To: Final comment - Planning application 2026/91900 – Supplementary
objection regarding access to No. 68

I wish to submit an additional comment regarding the accuracy of the submitted plans.

Proposed Ground Floor Plan

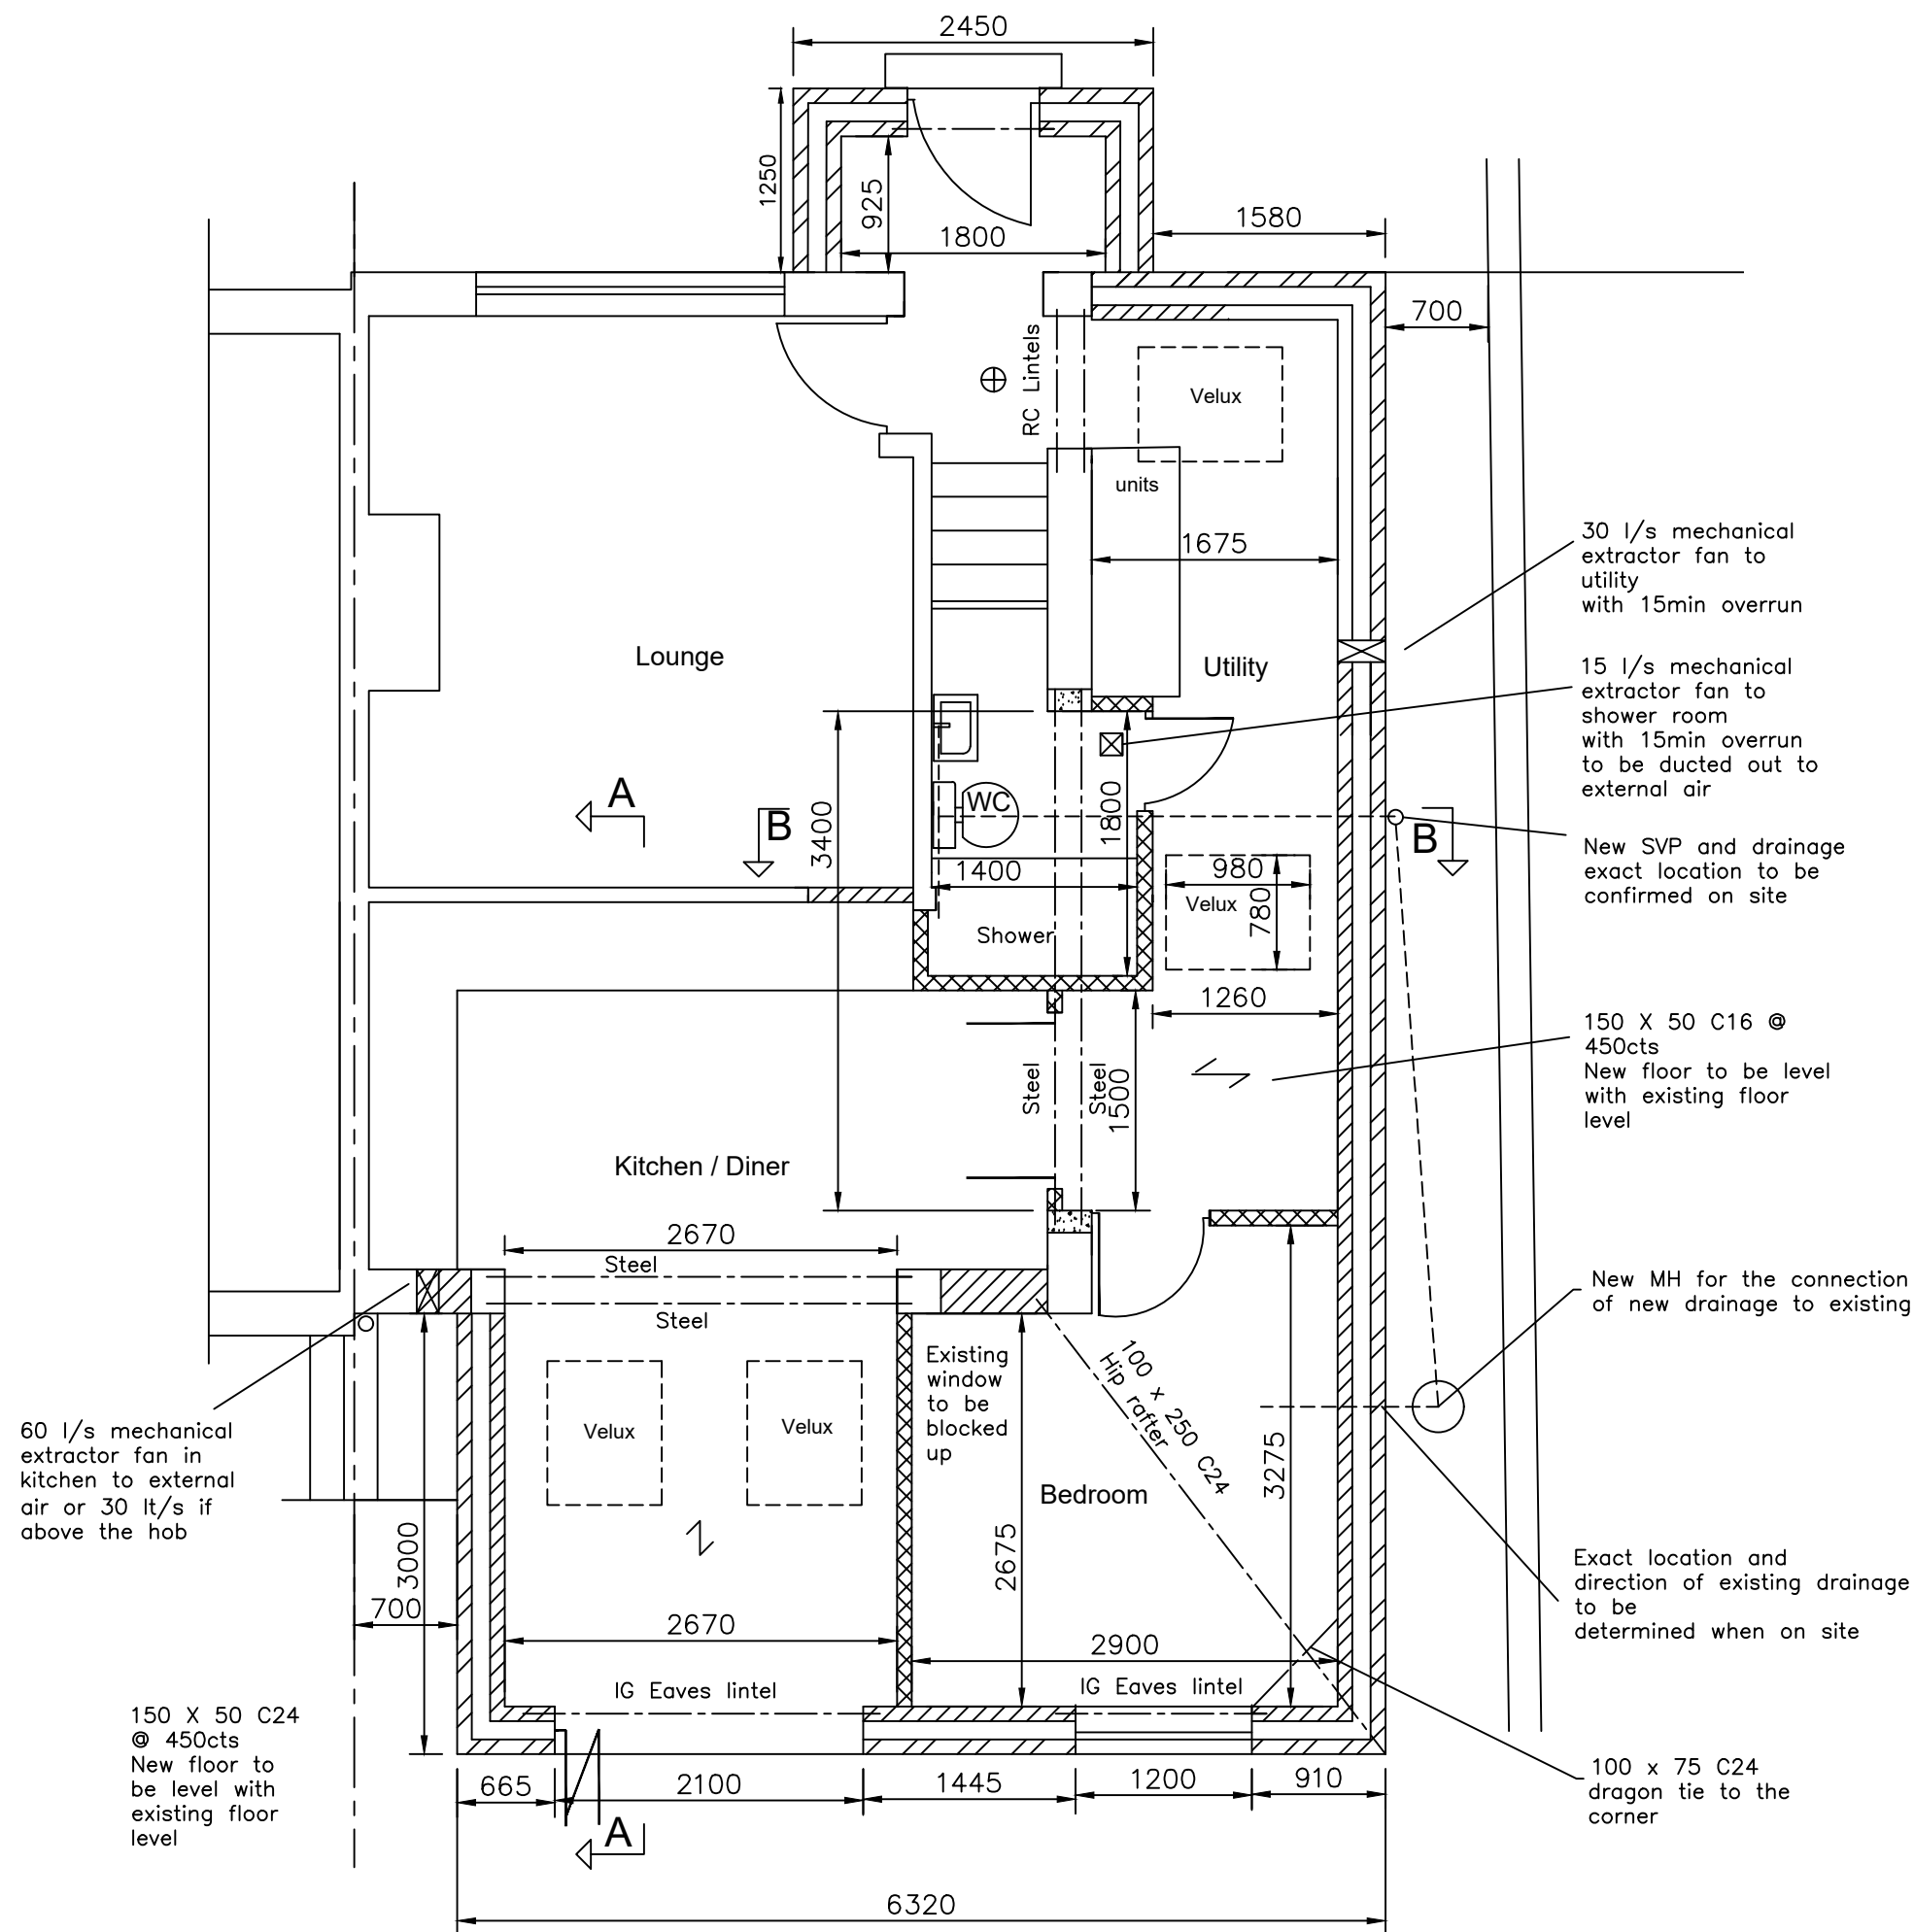
In the current application, this recess has been omitted, and the gap between the boundary wall and the proposed extension has been reduced on the new drawings. This change does not reflect the actual site conditions. The omission makes the access appear straighter and wider on paper than it is in reality.

The actual usable width is significantly narrower due to fixed structural features, including the step projection, drainpipe projection, brick nib, and the recess geometry itself. These features are permanent and cannot be removed without major structural alteration.

Because these fixed features materially reduce the usable width, the omission of the recess and the reduced gap on the new plans means the submitted drawings do not accurately represent the existing site geometry. This directly affects the assessment of whether access to No. 68 can be maintained, as stated on the site plan ("access to be maintained for No. 68").

I respectfully request that the officer assess the access using the correct boundary geometry shown on the previous plans, which accurately included the recess and the true gap width. The current drawings do not provide a reliable basis for assessing access, amenity impact, or the practical implications of the proposed extension.
